# CITY OF ALBUQUERQUE

RE: **Lot 12 Block 9 Unit 18 Volcano Cliffs SAD 228**  
**8520 Papagayo NW**  
**Grading and Drainage Plan**  
**Engineers Stamp Date 4/21/17 (D10D003I12)**

Based upon the information provided in your submittal received 4/21/17, this plan is approved for Grading Permit. **Prior to building permit approval, a pad certification will be required.** A hold on the property will be placed until this certification has been approved.

ENGINEER'S SEAL 4/21/17 DAVID SOULE P.E. #14522	LOT 12 BLOCK 9 VOLCANO CLIFFS UNIT 18	DRAWN BY JDG
	GRADING AND DRAINAGE PLAN	DATE 04-17-2017
 Rio Grande Engineering 1606 CENTRAL AVENUE SE SUITE 201 ALBUQUERQUE, NM 87106 (505) 872-0999		SHEET # 1 OF 1 JOB #

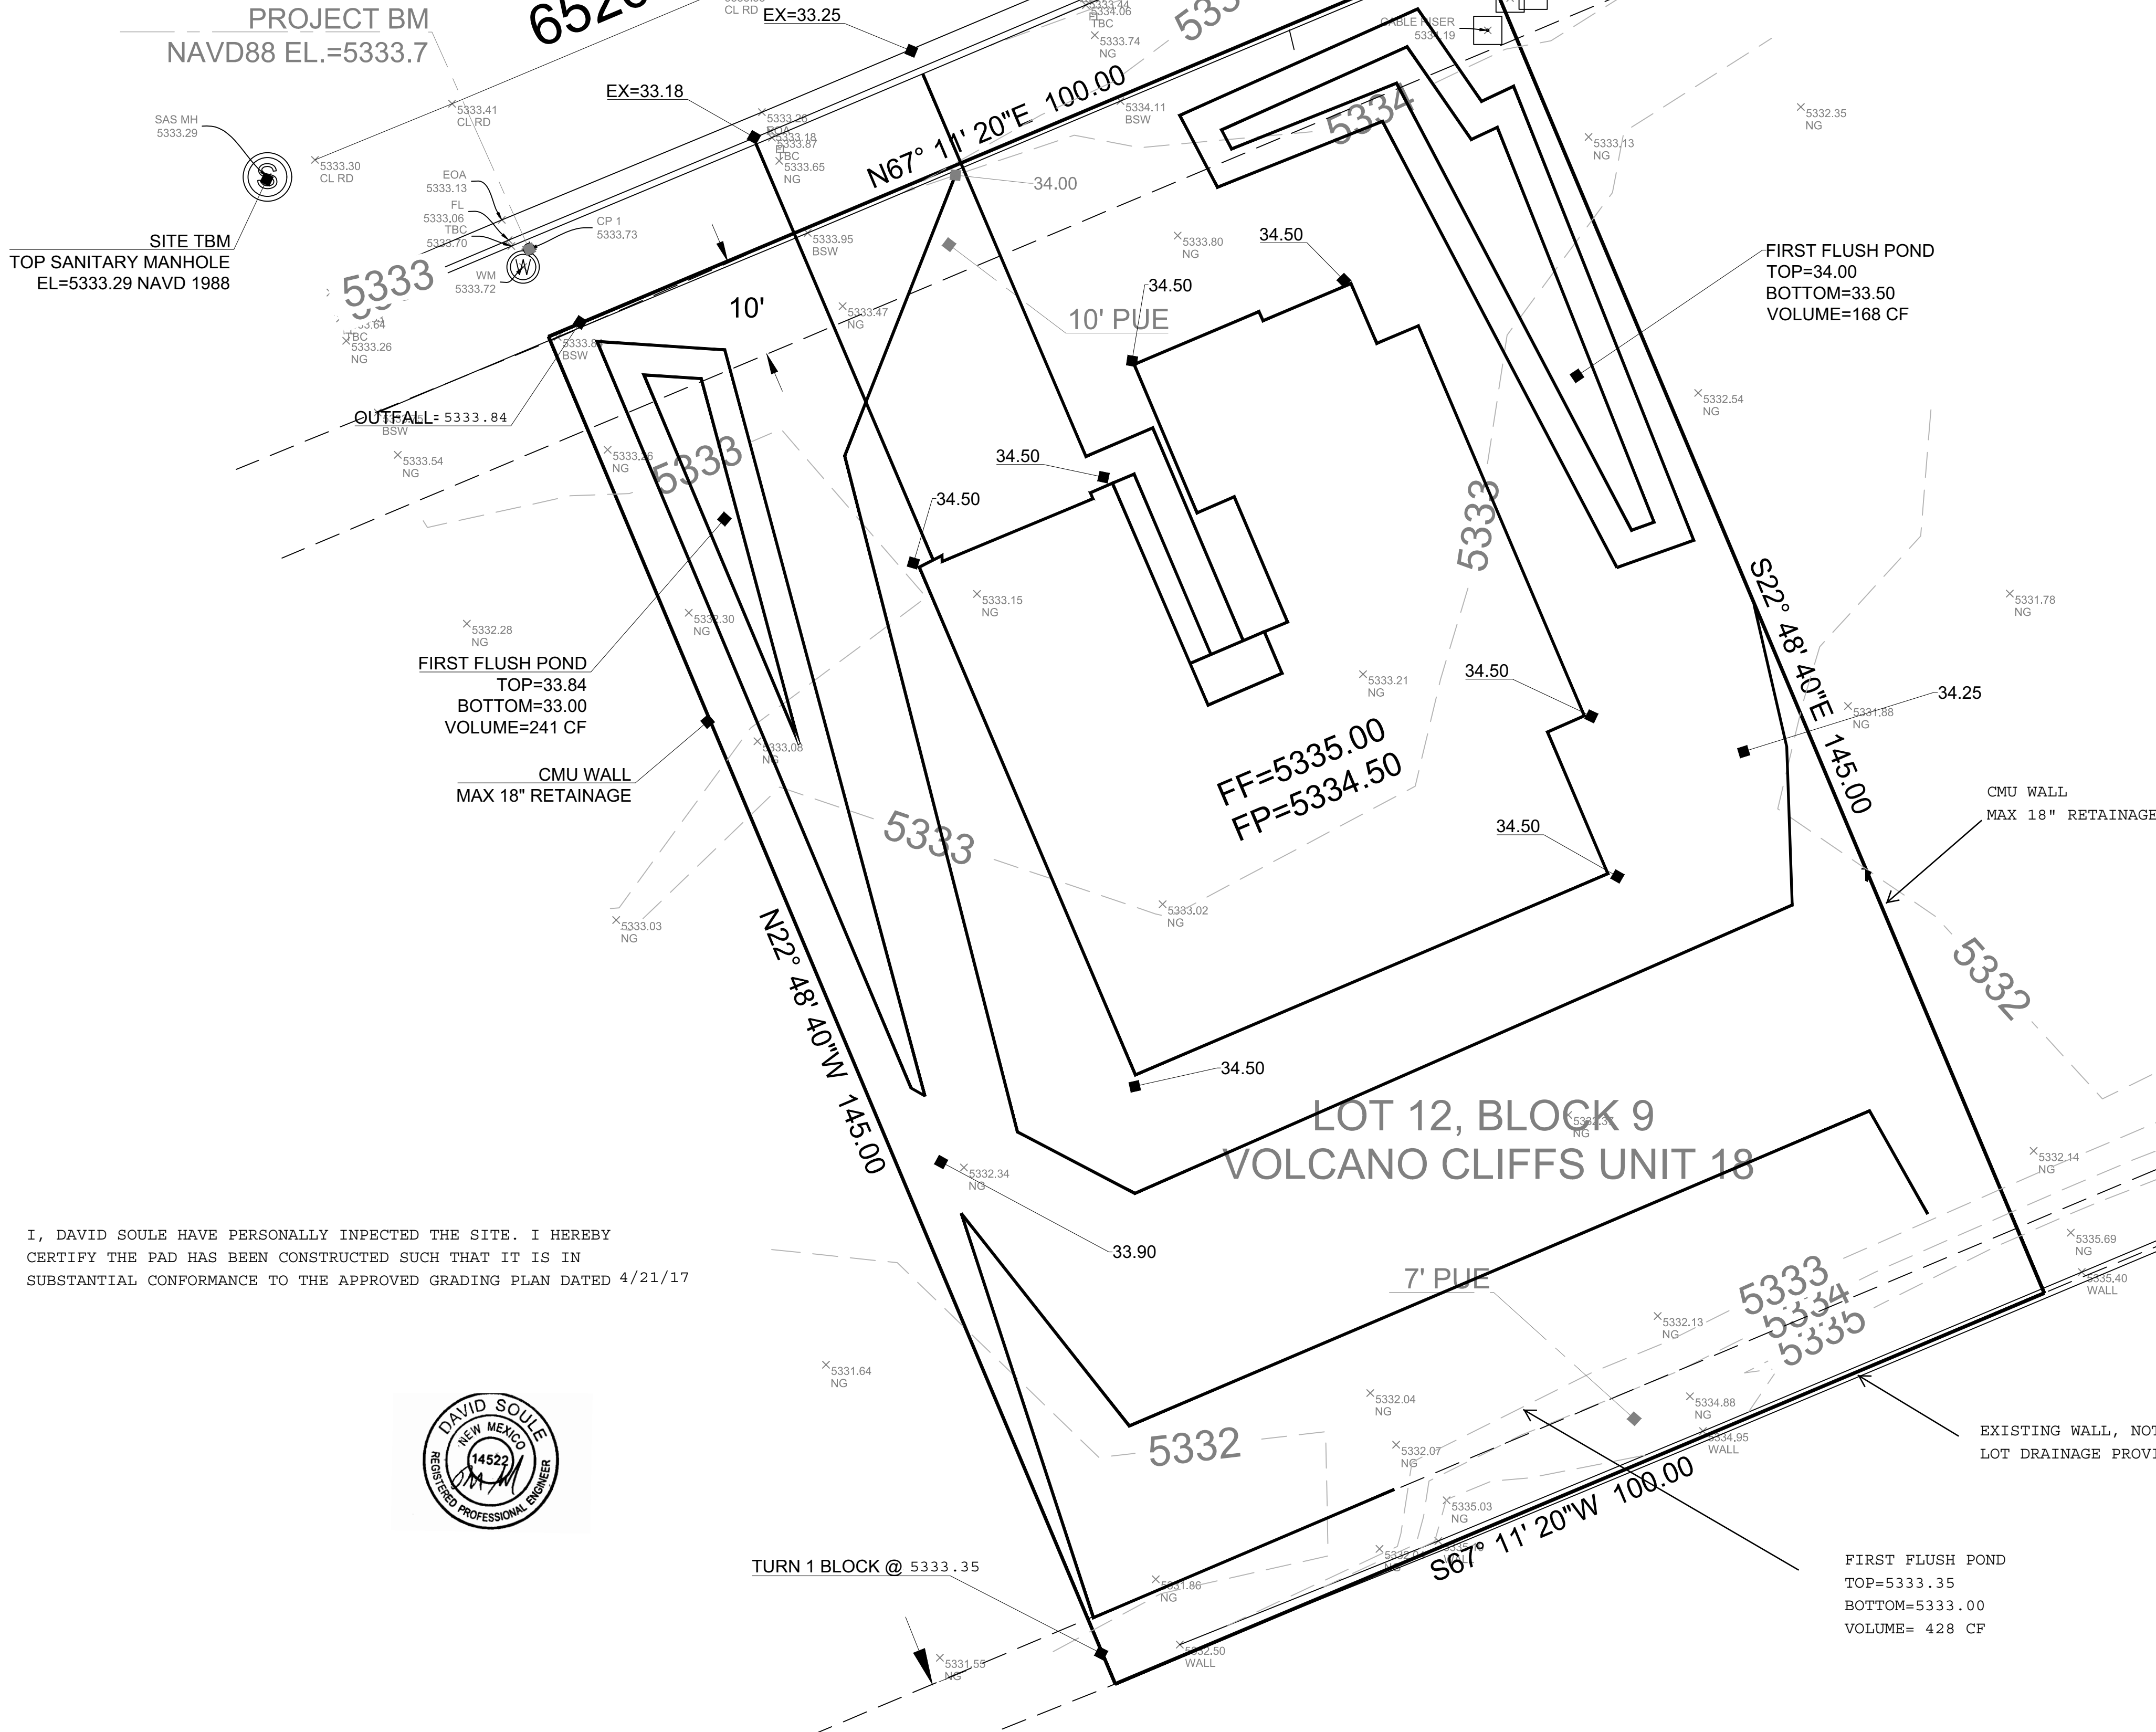
- Provide an opening in Garden Wall at the SW corner. **Added**
- Provide the water quality ponds in the rear yard where cross lot flow is to be provided. Flows do not need to leave front yard. **Added**
- Provide calculations for the openings in the walls. **Attached**

**Added note regarding pad certification**

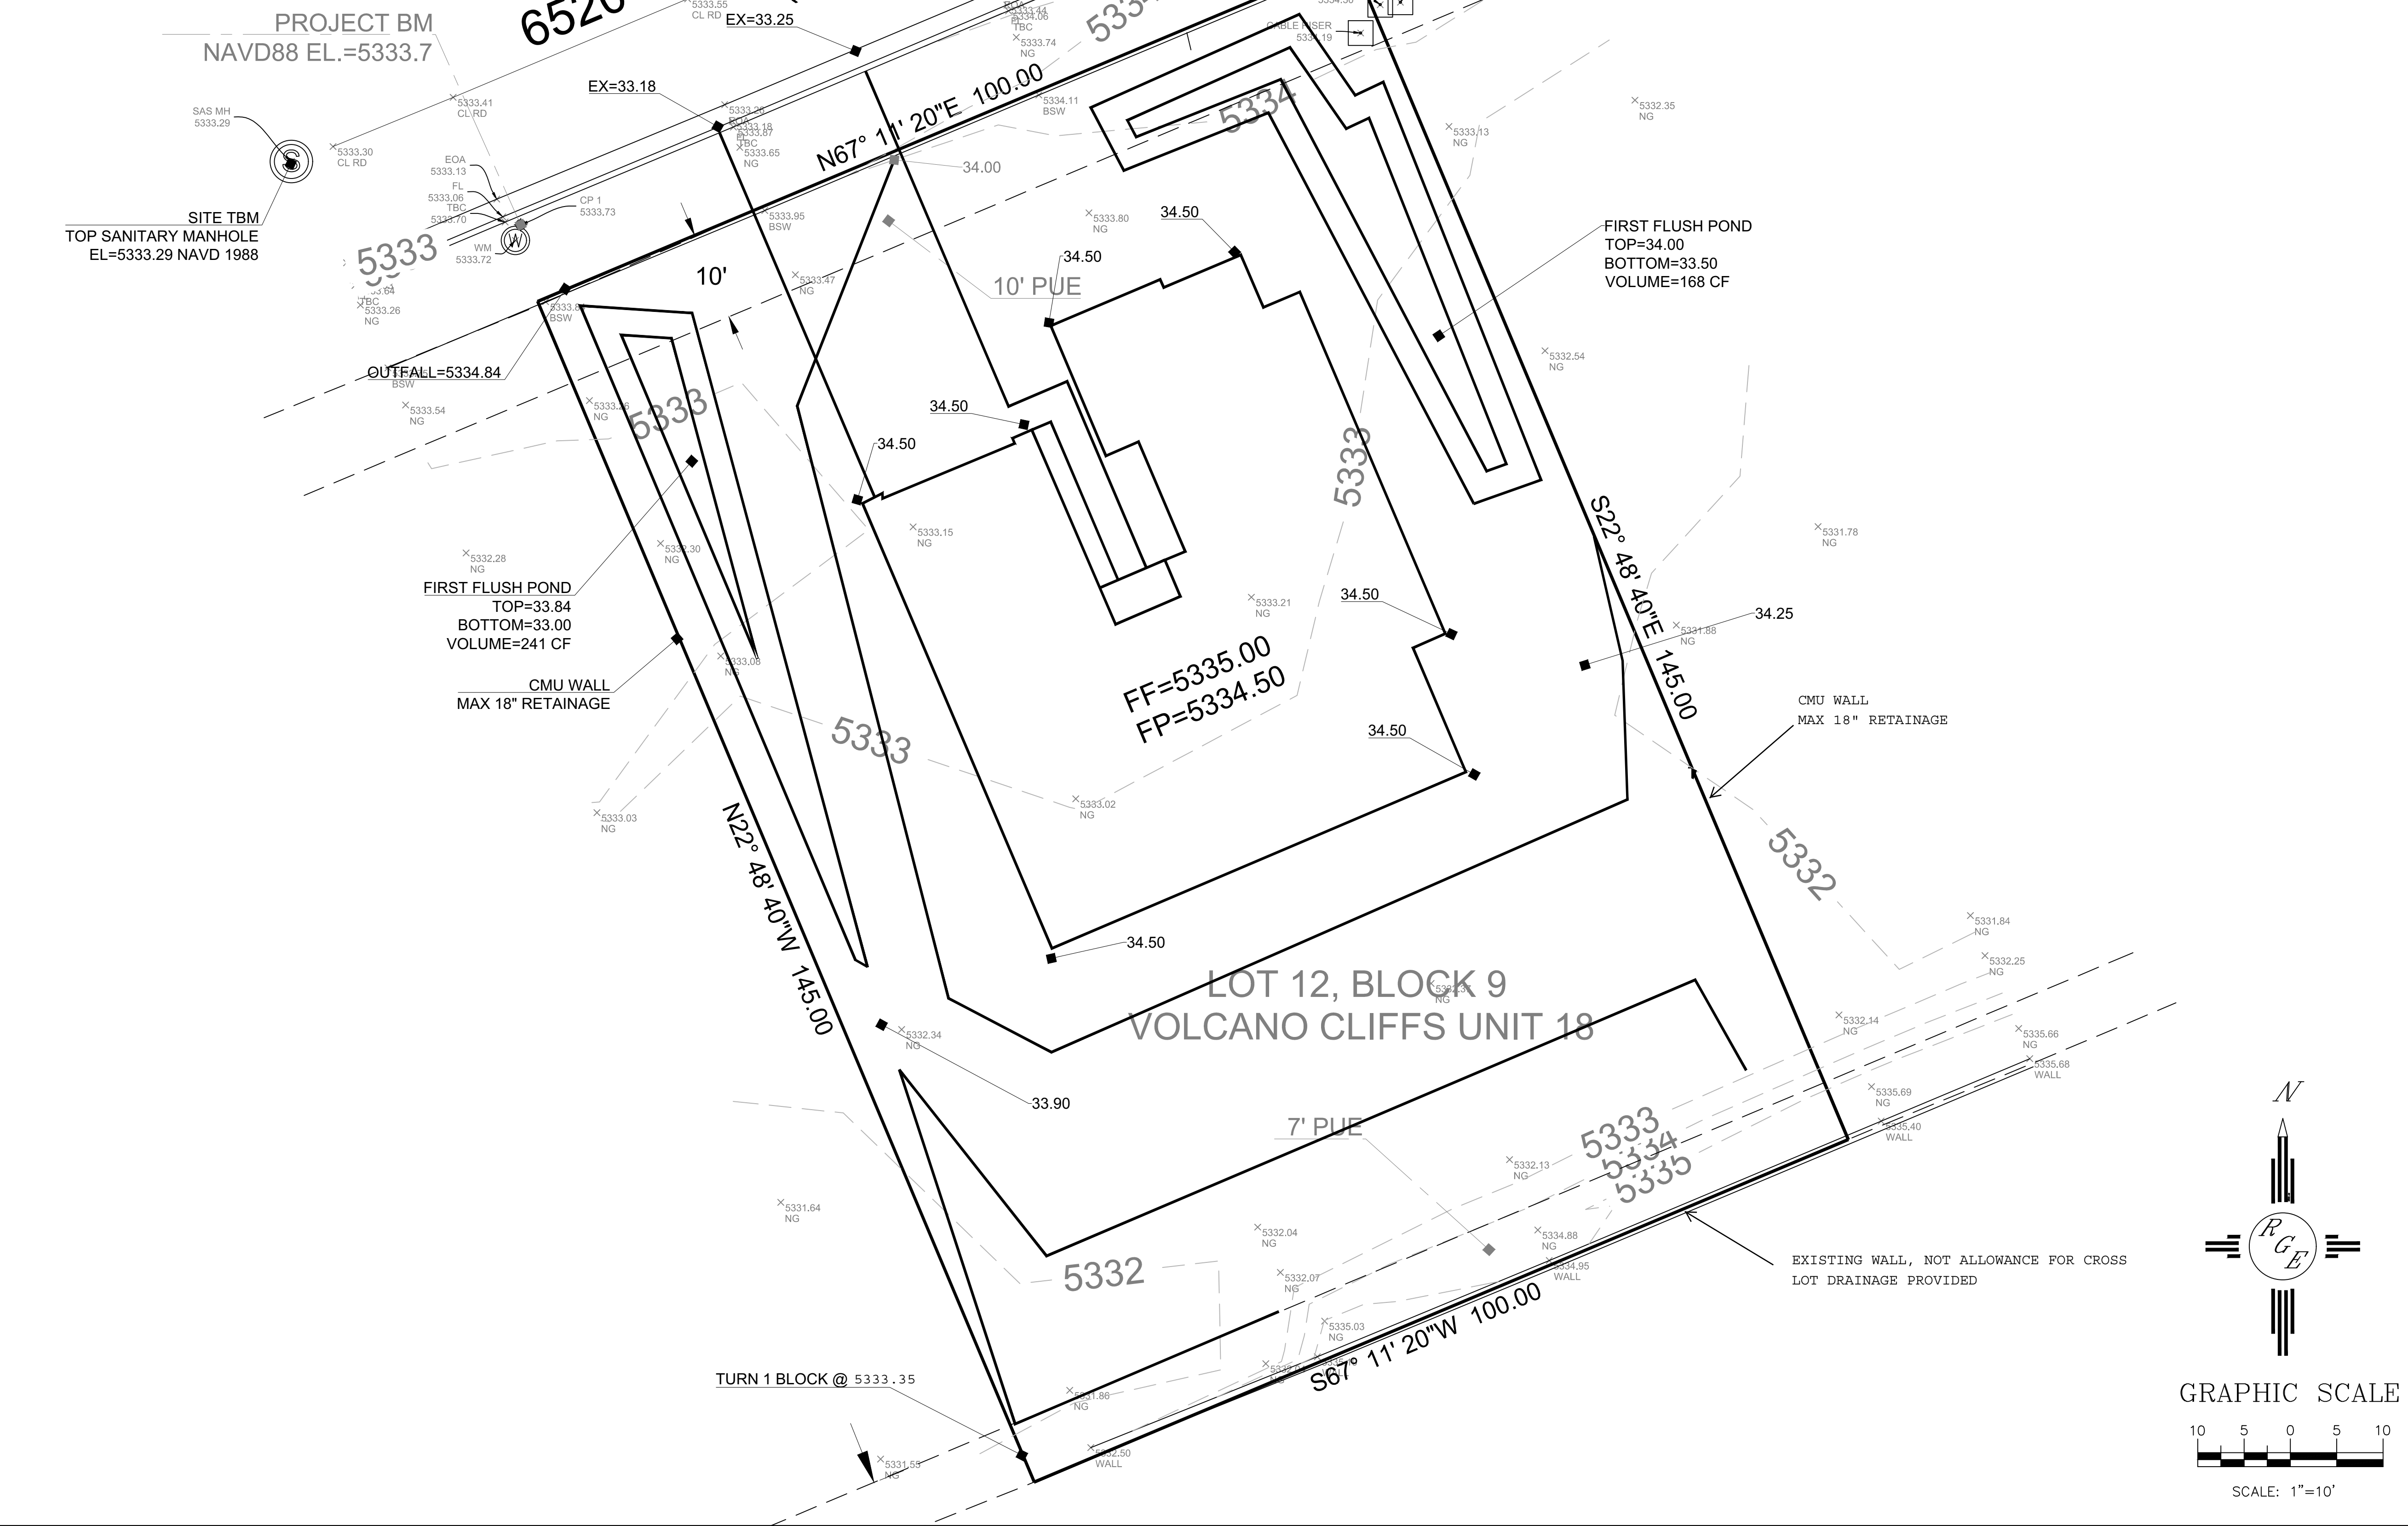
Based upon the information provided in your submittal received 4/18/17, this plan cannot be approved for Grading Permit until the following comments are addressed.
